ENG-SP20003-R5-PrelimPlan.pdf Markup Summary

5
OF 17

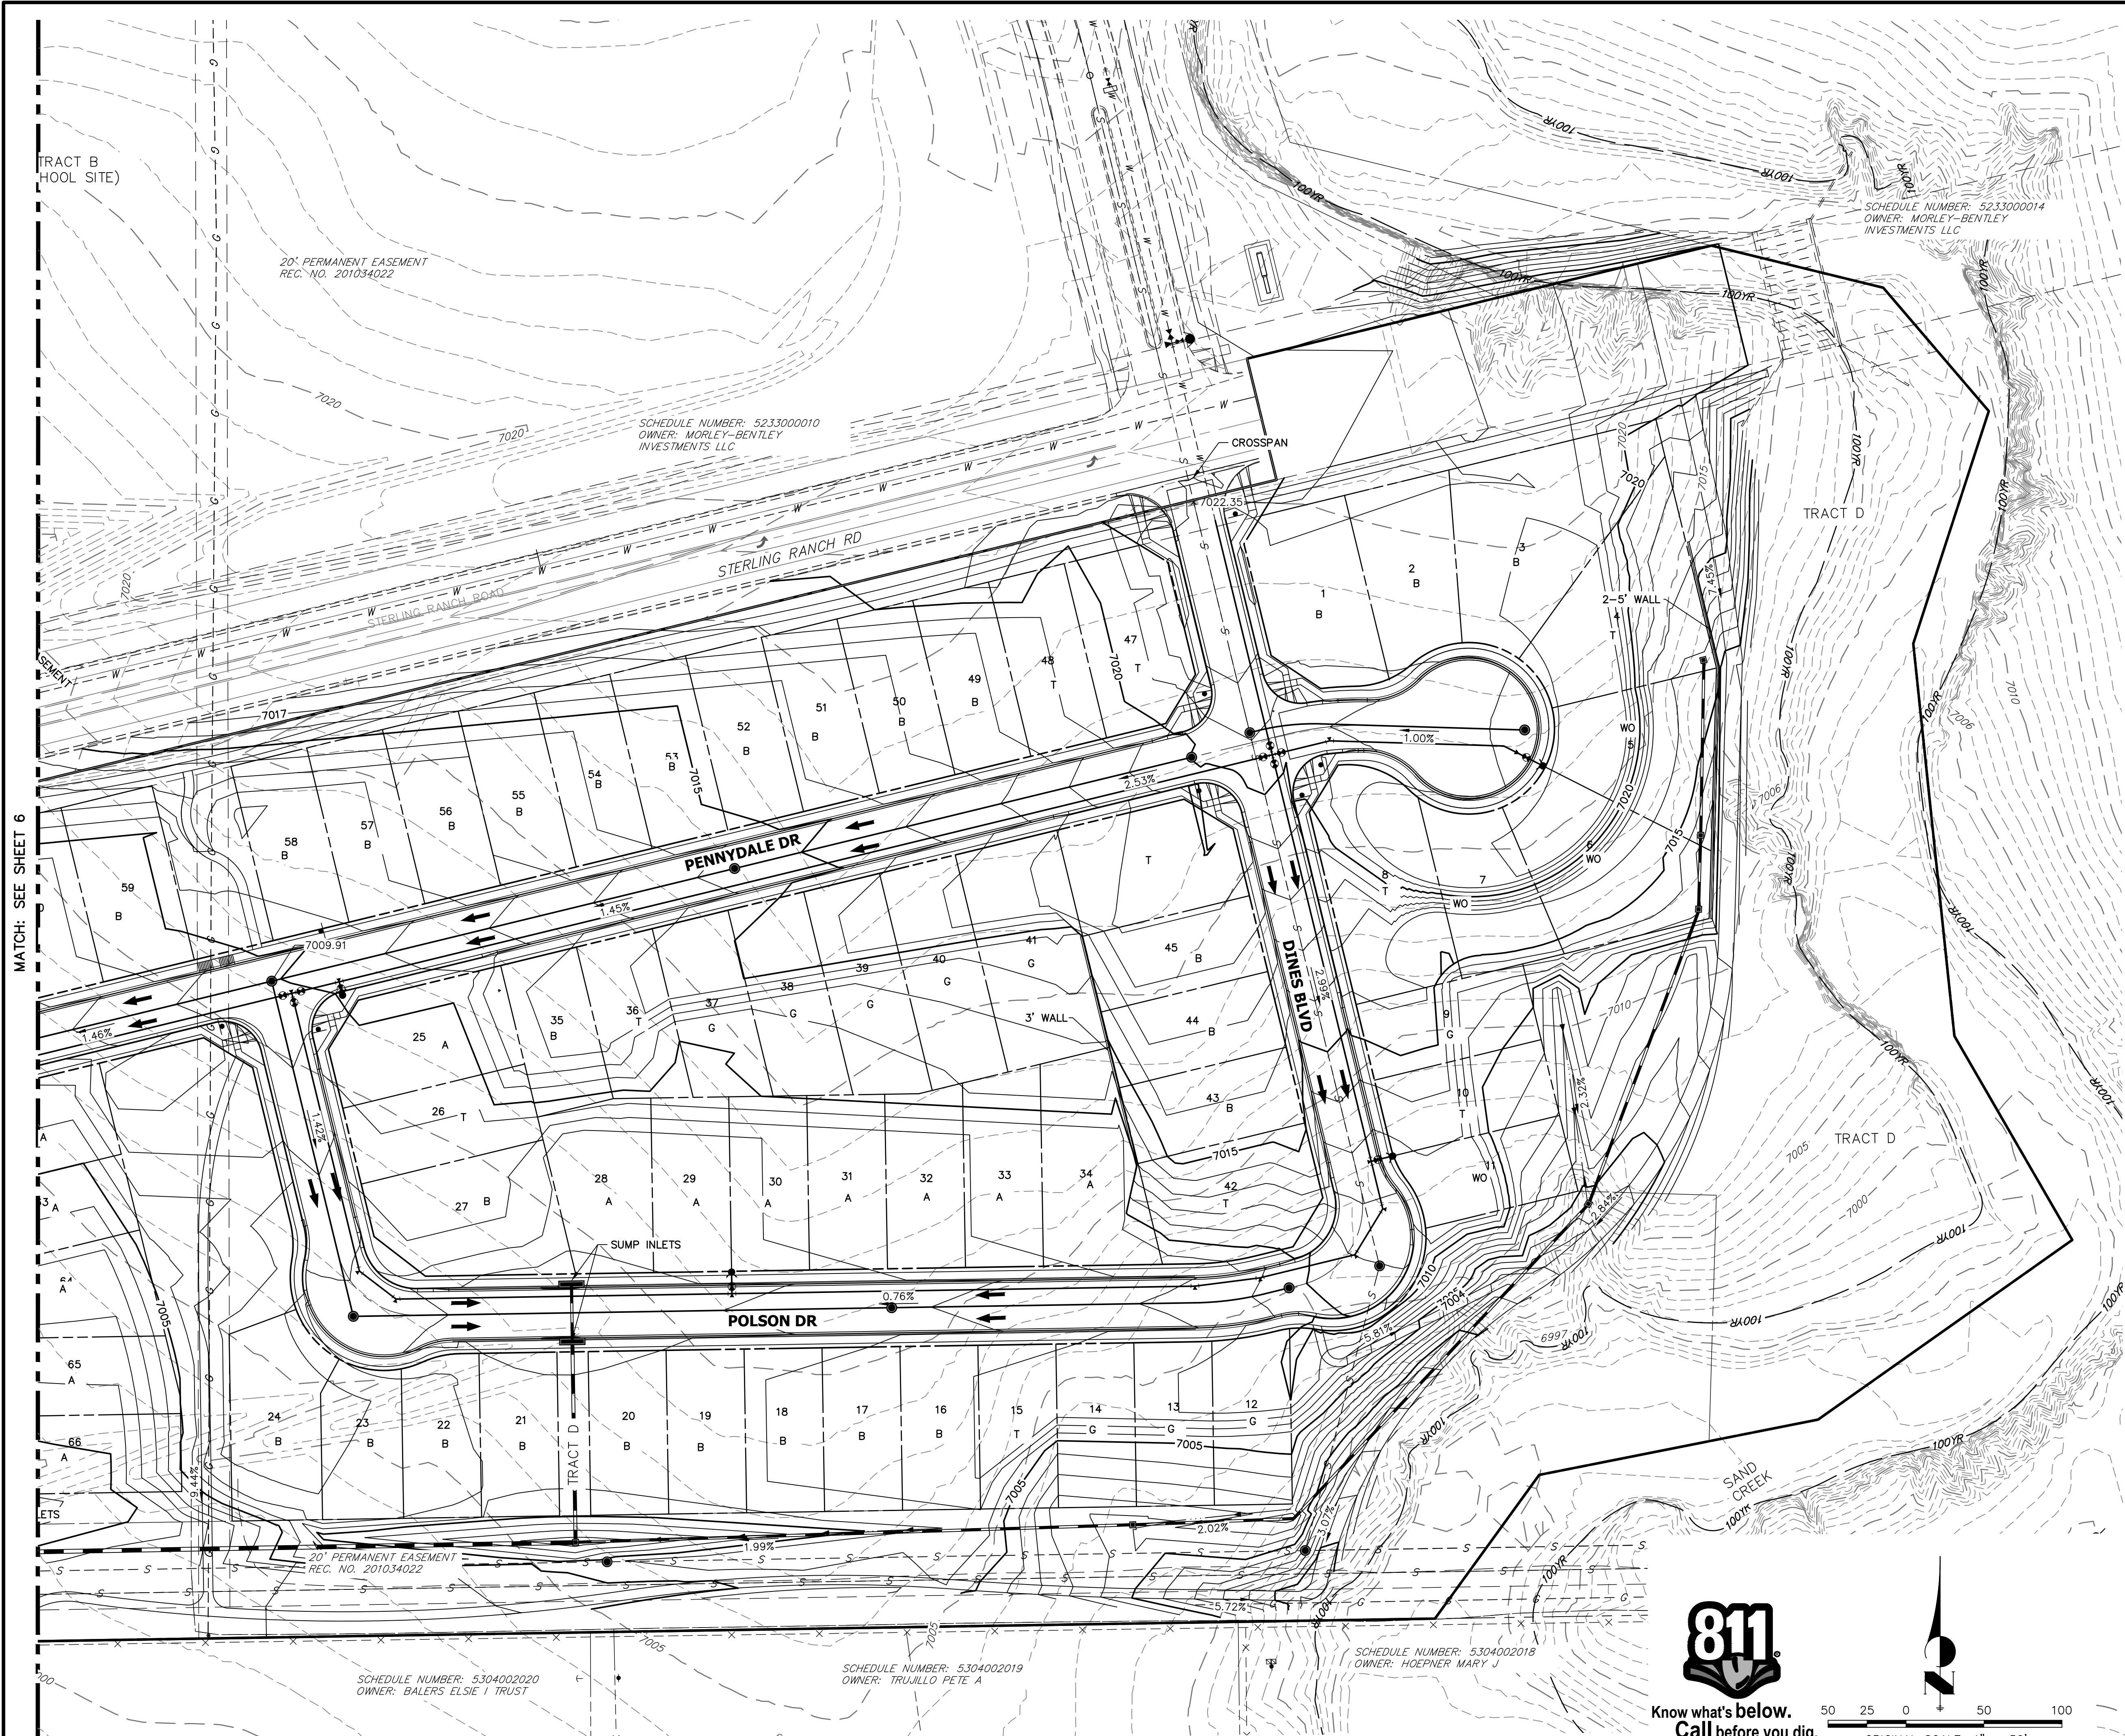
Dimensions/ Tract boundary shall close (Repeat comment)

dimension

dimension missing- check all tracts verify every line has dimensions all sheets

If a retaining wall is needed between lots here, add a note that an easement will be provided and district or HOA will maintain it.

STERLING RANCH PHASE 2		PRELIMINARY GRADING PLAN	
SHEET	6	OF	17
JOB NO.	25188.02

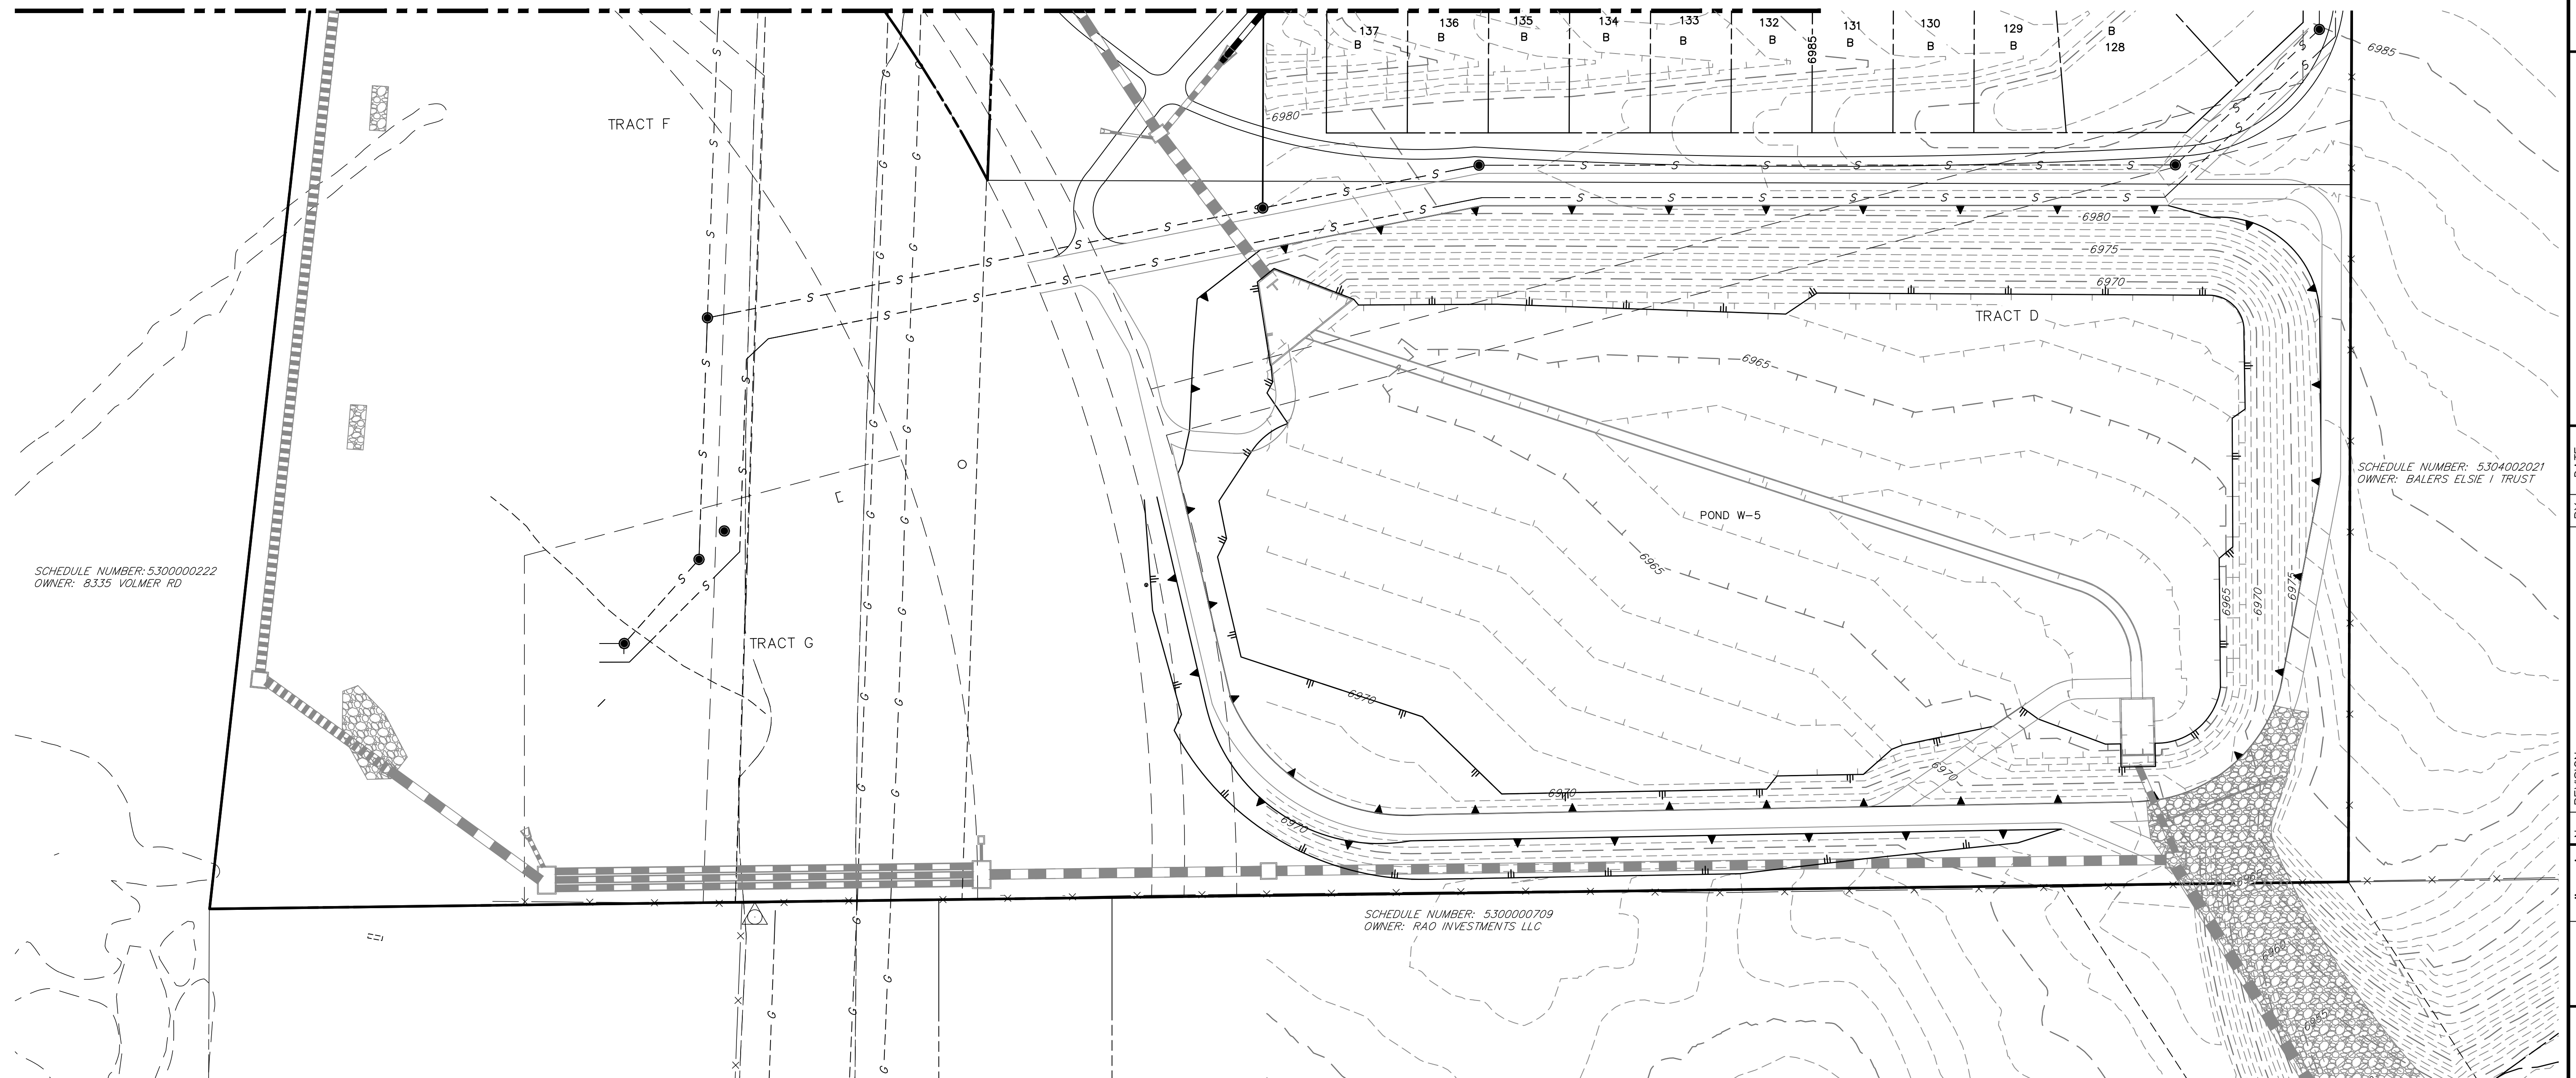
If the school district will not allow this drainage swale, a different solution is required.
